ARUN PLANNING
ARUN CIVIC CENTRE
MALTRAVERS ROAD
LITTLEHAMPTON
WEST SUSSEX
BN17 5LF

26/10/2014

REF AW/213/14/PL

Existing floor plan
No. 4 Release Close

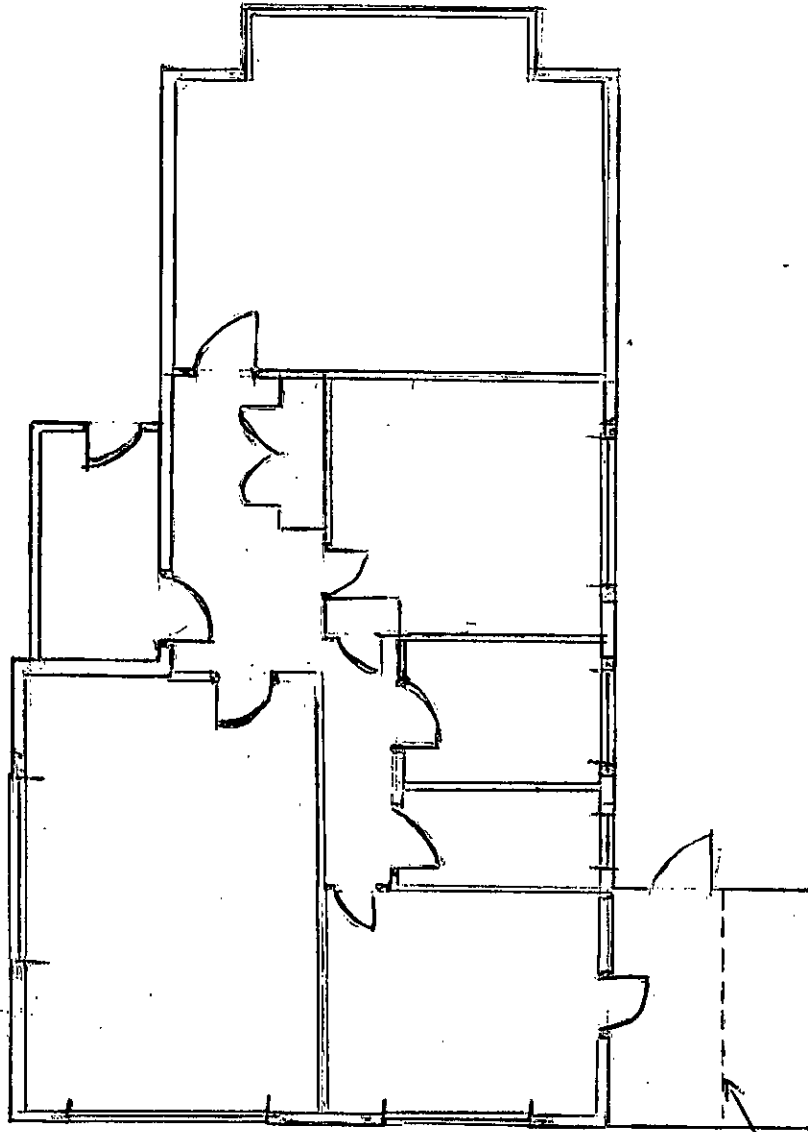
The existing number 4 shows a larger internal layout possible a 2 bedroom property.

1:100 Proposed Drawing. 006

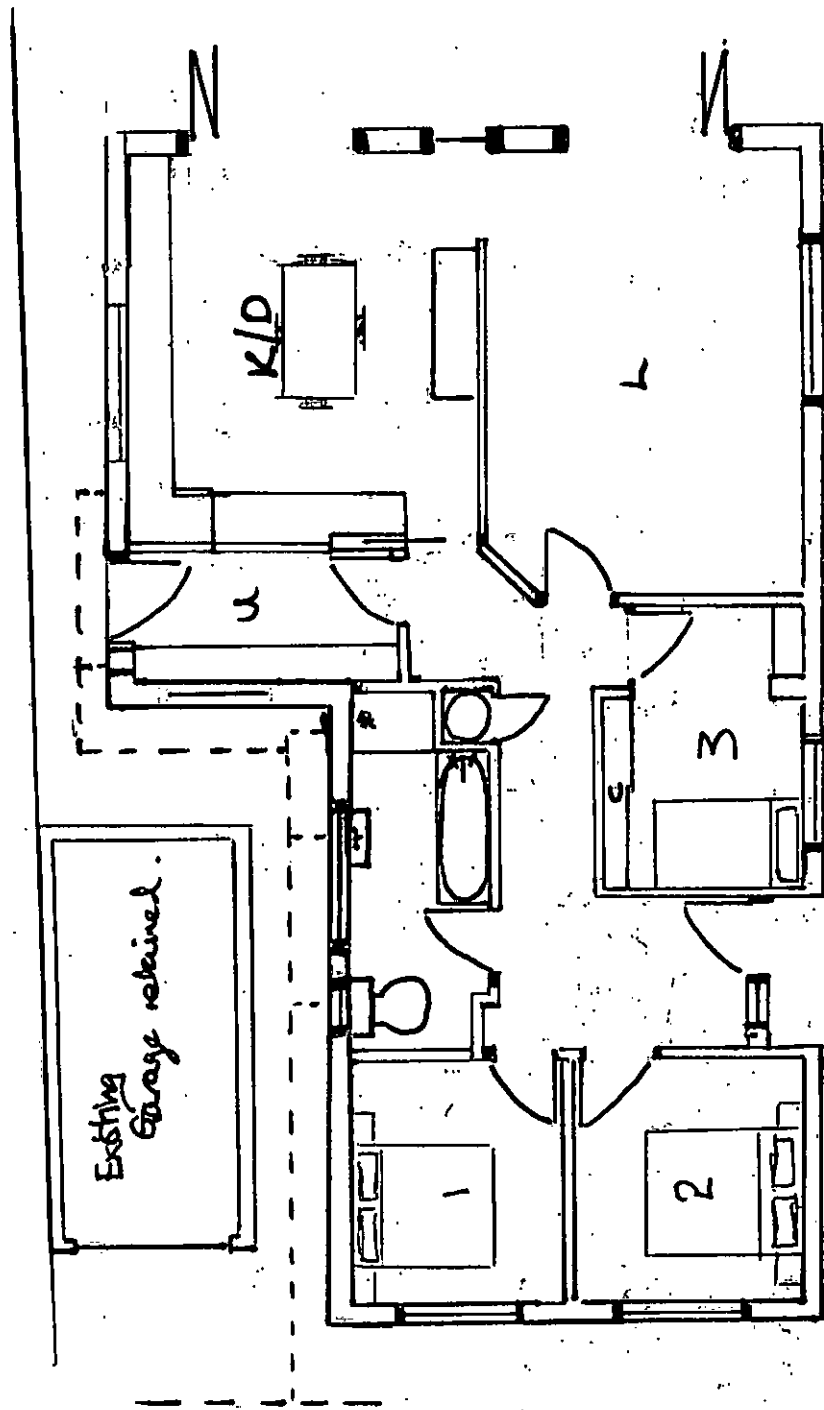
In the design statement for the local plan 2014 a rear garden should be a minimum of 10 meters for sitting out, clothes drying, a small shed, play area as well as space to plant shrubs etc. The applicant states a 8 metre rear garden. The scale on the drawing shows 7.5 metres.

The internal layout of this 3 bedroom detached new bungalow shows the size of kitchen/dinner is undersize as is the bedrooms 1 & 2 as to the local plan for good design Policy DDH2.

Other concerns are the existing foul drain being close to the foundation of the new build. Narrow pathways between bungalows giving maintenance to each hard to work on.
